Our ref: XA/2024/100196/01-L01
Your ref: EN010122
Date: 31 October 2024

**EXAMINATION DEADLINE 5 - ACTION POINTS FOR ISSUE SPECIFIC HEARING 1.
OAKLANDS FARM SOLAR PARK, DERBYSHIRE.**

On 22nd of October 2024, the Applicant submitted to us an updated Flood Modelling Report, referenced P20209_R5 and dated October 2024, for review.

Figure 4.11: Indicative Access Track  
Cross Sections (4.5m/6m/3.5m)

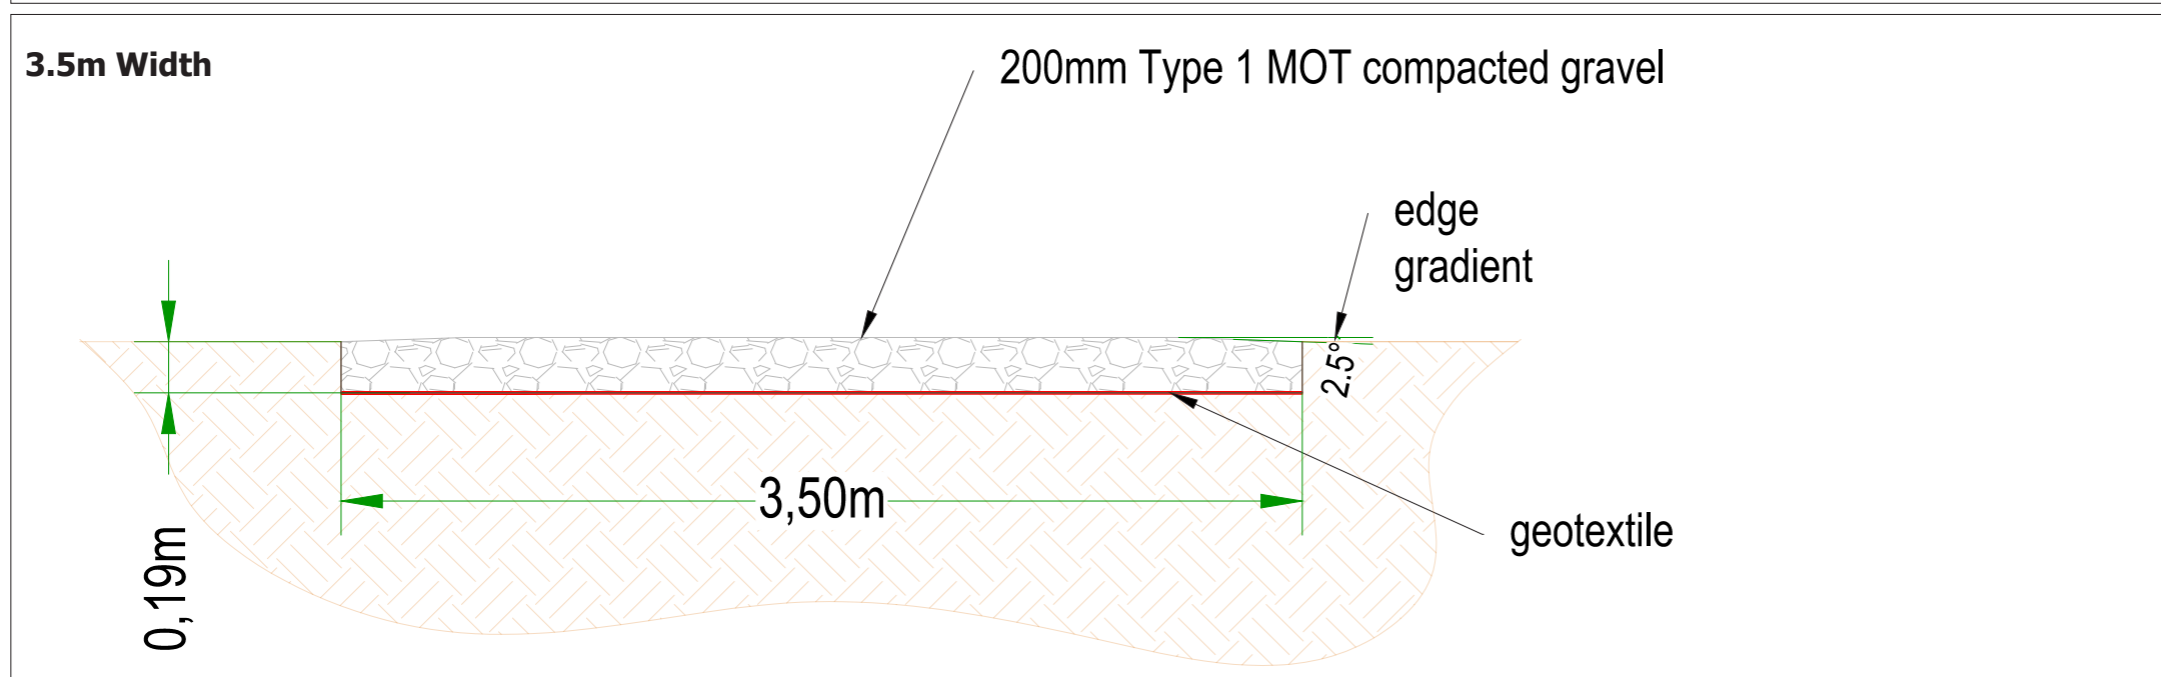
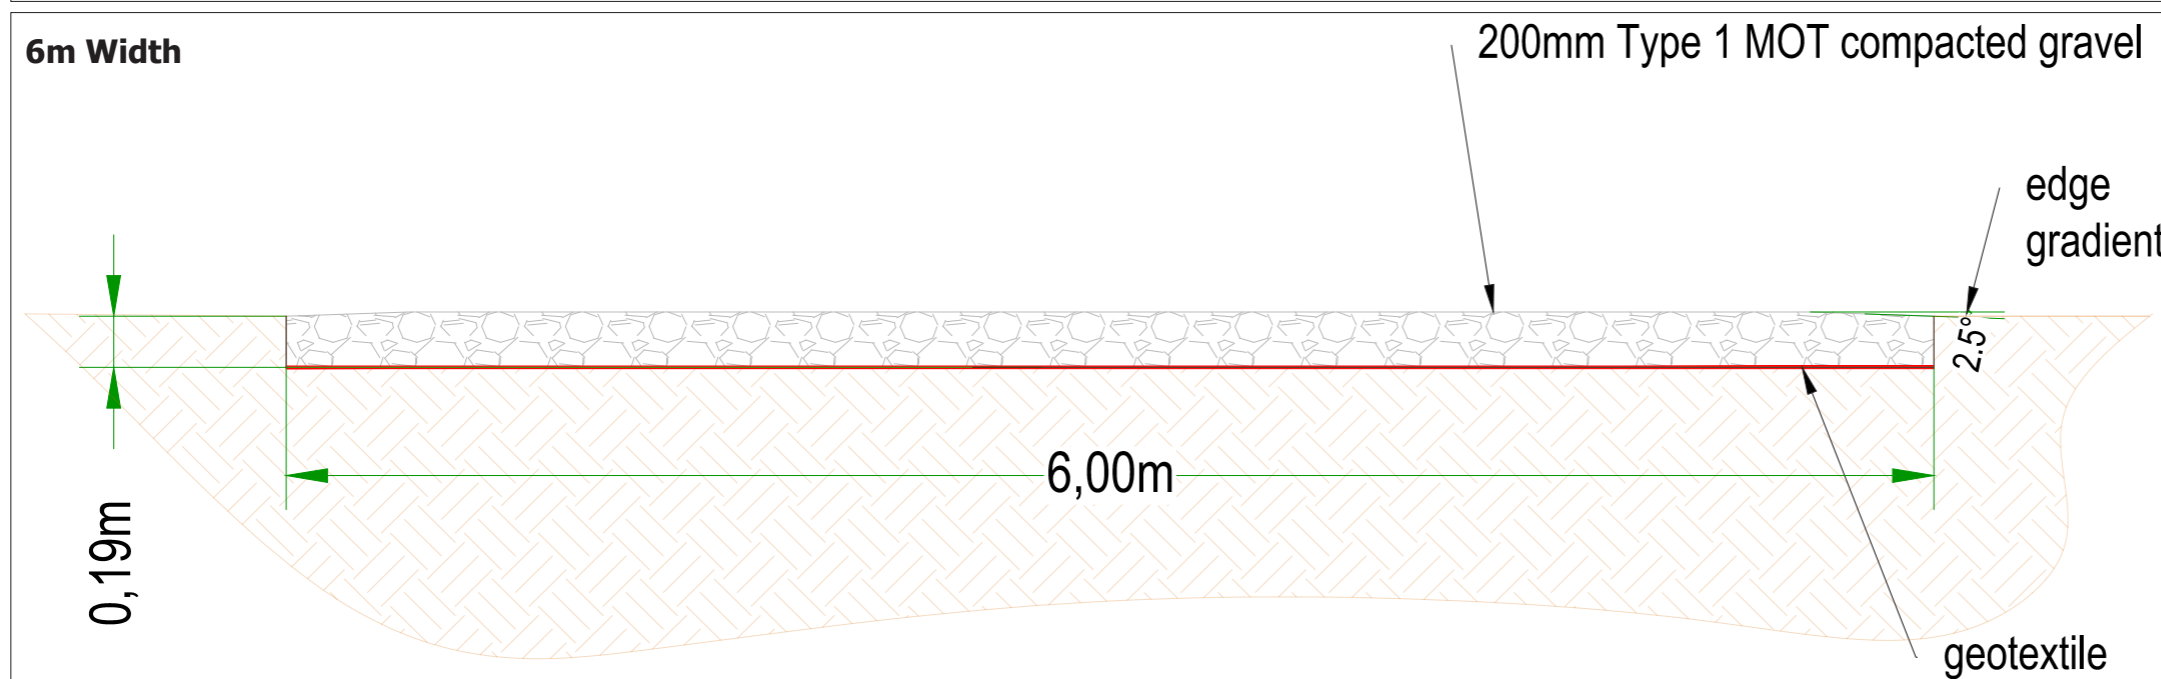
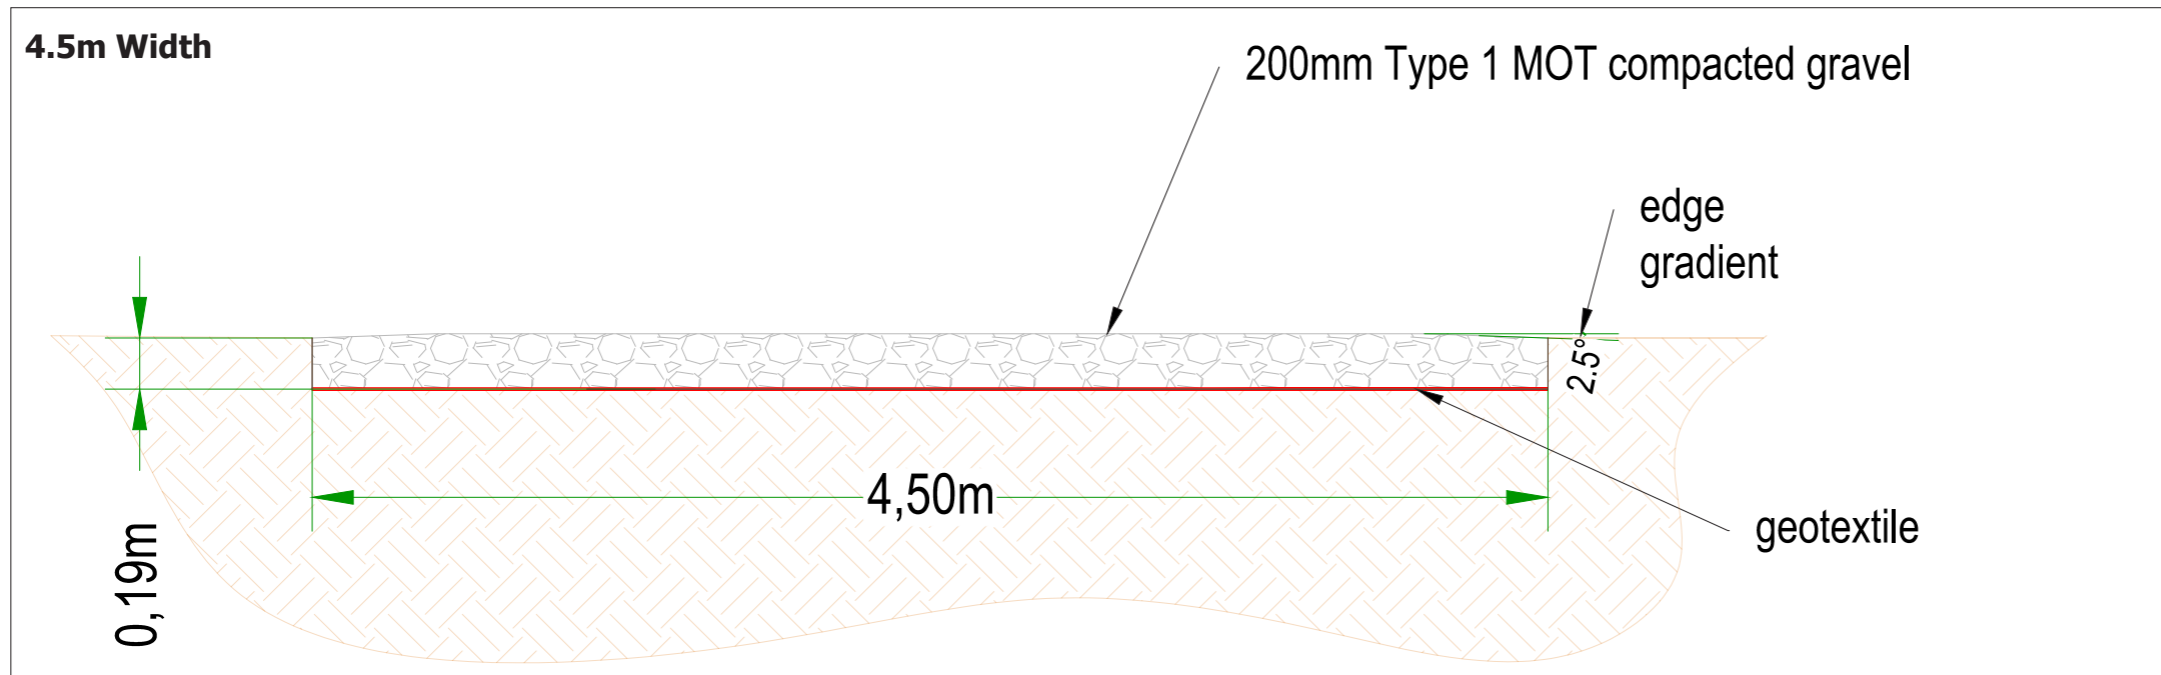
However, this document also tests the impact of raising the proposed access track crossings to be above the 1% (1 in 100) annual exceedance probability (AEP) plus climate change flood levels. Unfortunately, we note that the off-site impacts, particularly in the pond area in the 3.3% (1 in 30) AEP scenario remain as in the previous submission, where the bridge soffit levels were lower. Whilst we note that there are areas of betterment outside of the order limits for the development, given the increase in water levels within the pond area of around 0.17 metres in the 3.3% (1 in 30) AEP scenario, and the areas of additional flooding outside of the order limits, we cannot accept an increase of that magnitude without further mitigation or landowner agreement. We suggest the following considerations as a way forward for the Applicant:

1. At Issue Specific Hearing 1, on Tuesday 22 October, the topic of the three

proposed access crossings was discussed. This raised some questions about the need for these crossings - are they essential for the development, or could existing crossings be used instead? Removal of these new crossings from the proposals entirely will mean there are no resulting offsite flood risk impacts.

2. If new crossings are required, could these be limited to two crossings rather than three? The modelling shows that it is the most downstream crossing that appears to impact on offsite flood risk the most. If this crossing were removed from the proposals, this could potentially result in no notable increases to offsite flood risk.

3. If all three crossings are essential, are there any onsite mitigations which could limit the flow route on the right bank at the downstream crossing and hence reduce the associated off-site impacts?

4. Additionally, is there the opportunity to make all new crossings temporary, to be in situ for only the construction and decommission phases?
5. Finally, if the above options are not viable, can landowner consent be sought with respect to the offsite impacts? It should be noted that this is the least favourable of the options from the perspective of the Environment Agency.
